Final Report - Corrections Required **Application No. DEPN-26-0063**

Description : Single Family Detached residential development located north of New Life Drive in the Flying Horse Master Plan

Document Filename : DP Creekridge at Flying Horse Filing No. 1 V2.pdf

CREEKRIDGE AT FLYING HORSE FILING NO. 1

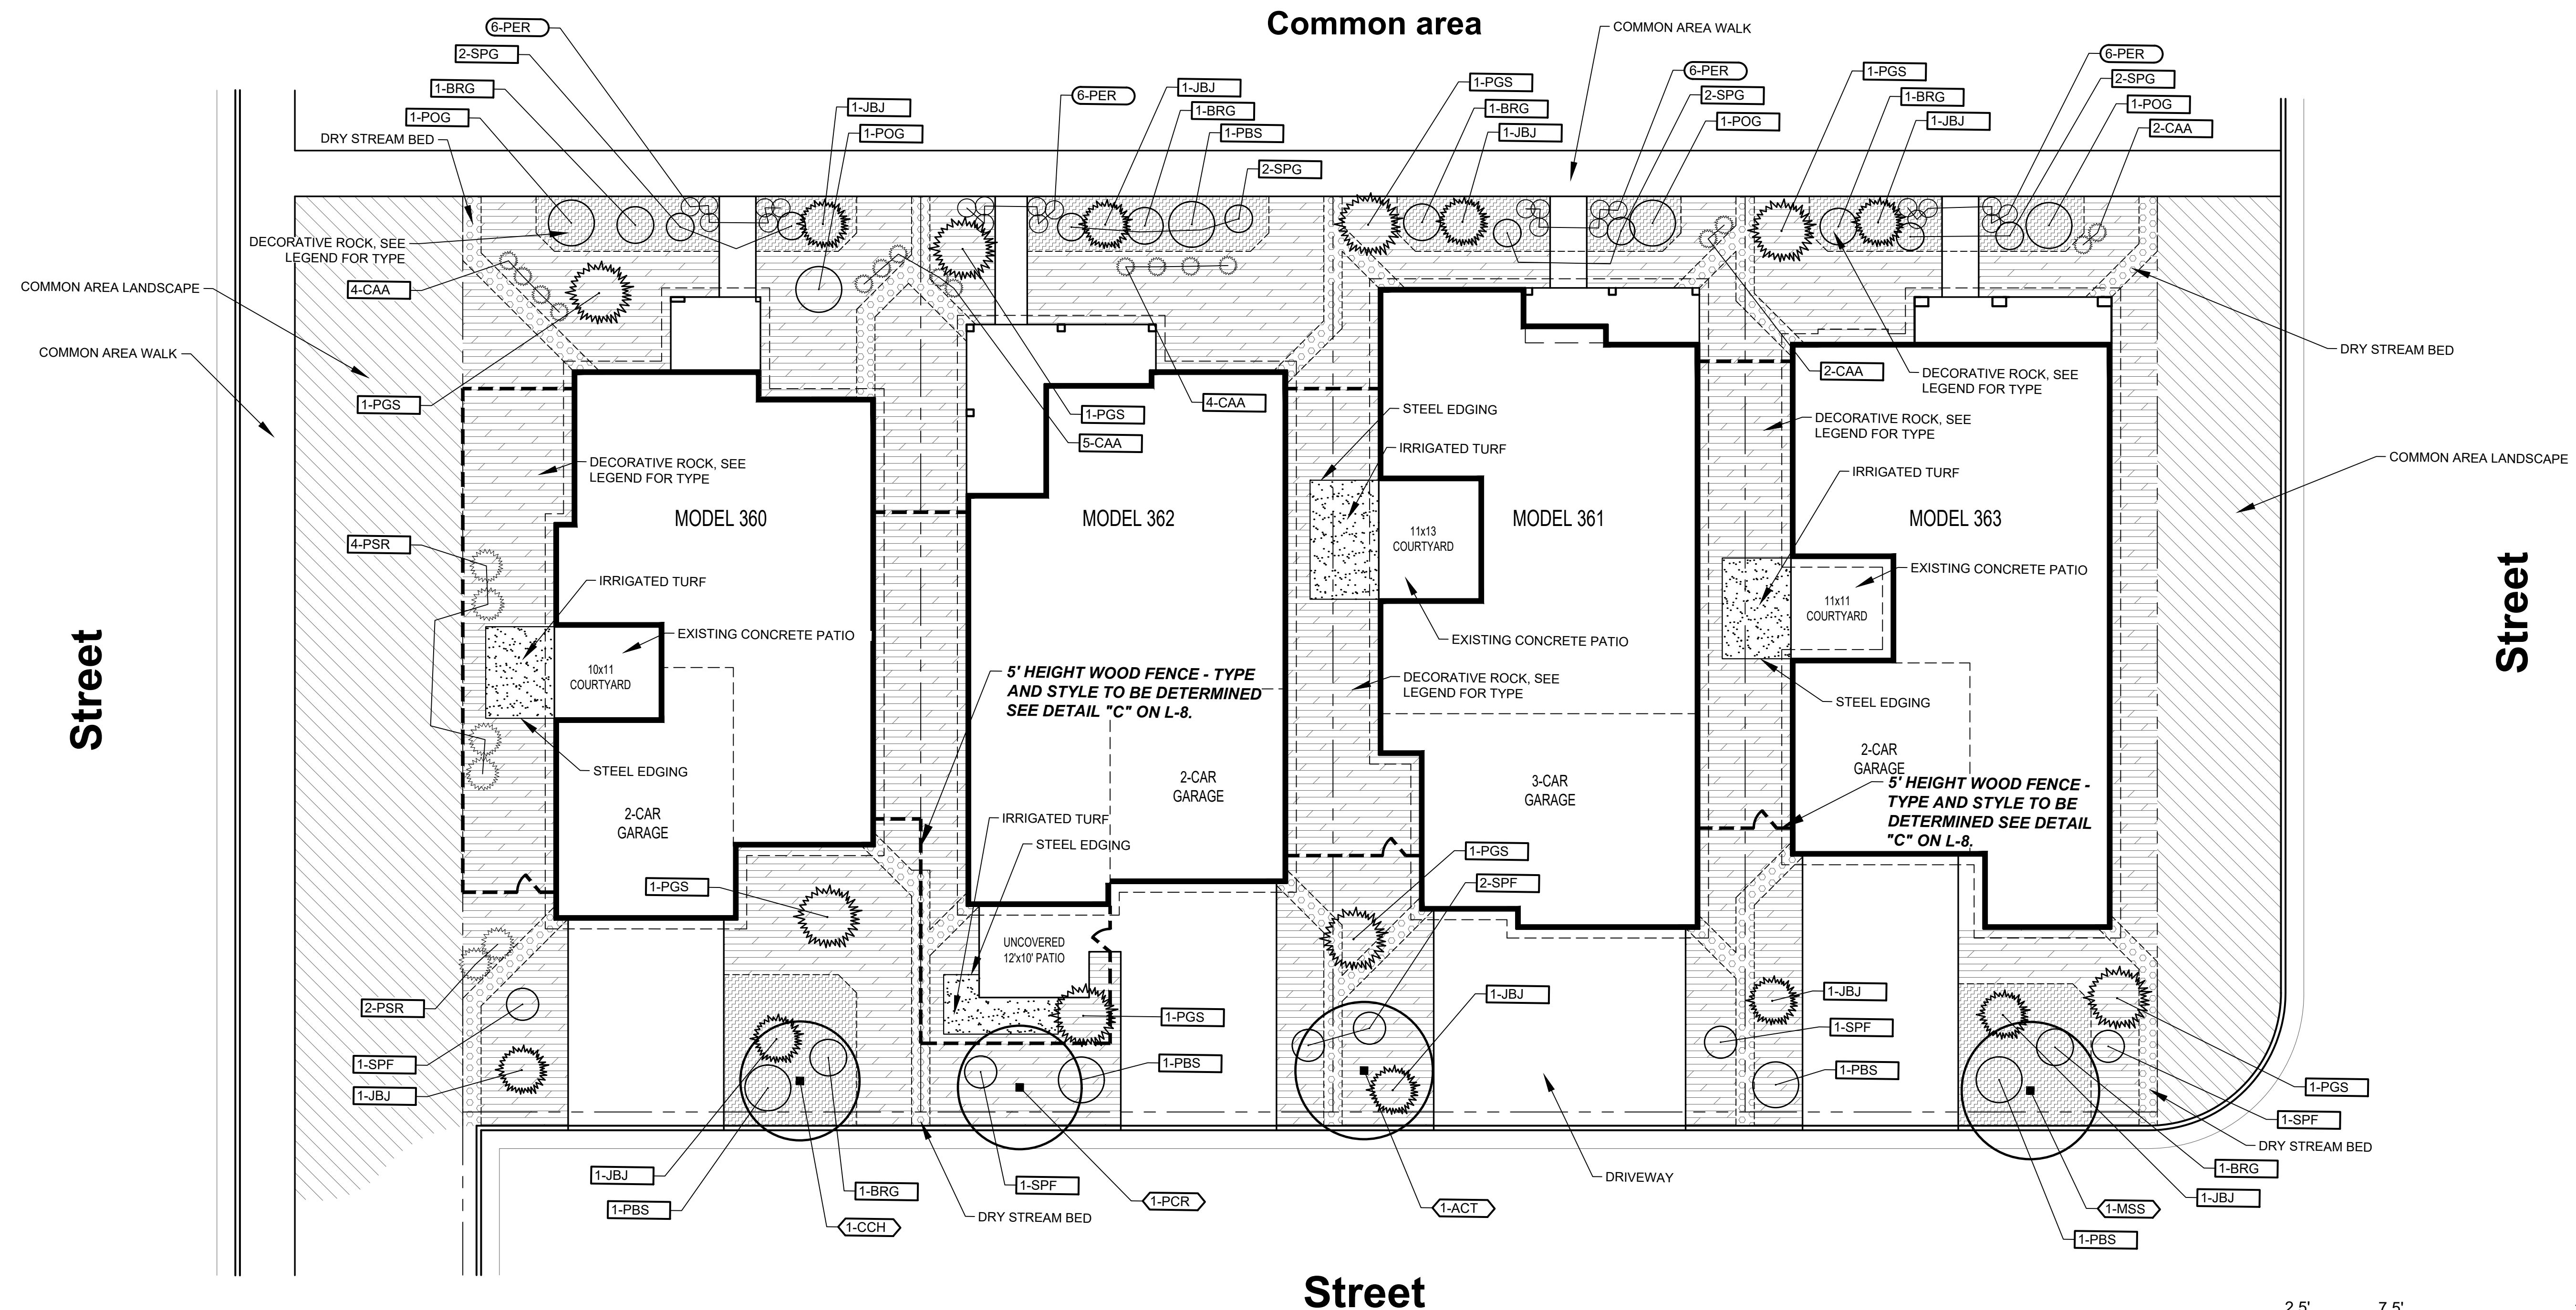
97	1	Caroline Miller : Planning	Additional Park Notes may be added upon next review.
101	1	Allison Stocker : Planning	See follow-up on ADA stalls.
109	2	Allison Stocker : Planning	will the vinyl fencing be on top of these retaining walls?
99	3	Allison Stocker : Planning	Lot 43
92	23	Gregory Stachon : Planning	don't see where the retaining walls are proposed. please label on landscape and grading plan if there are any proposed walls along with their max. height. Remove details if not used.
100	23	Allison Stocker : Planning	I am still having difficulty locating the proposed retaining wall and vinyl fence locations. Please make sure they are called out on the plan sheets
90	24	Gregory Stachon : Planning	The following notes need to be included with the landscape typical (COS Landscape Manual Appendix C) "All Trees located within City ROW are to be chosen from the current Forestry City Approved Street Tree List." "All required Compact Lot trees shall be installed by the developer/builder. Long term maintenance responsibility and irrigation for trees will be provided by _____ " (applicant to provide) "All required Compact Lot trees shall have an automatic irrigation system (drip/sod irrigation/etc.) which provides watering at time of planting."
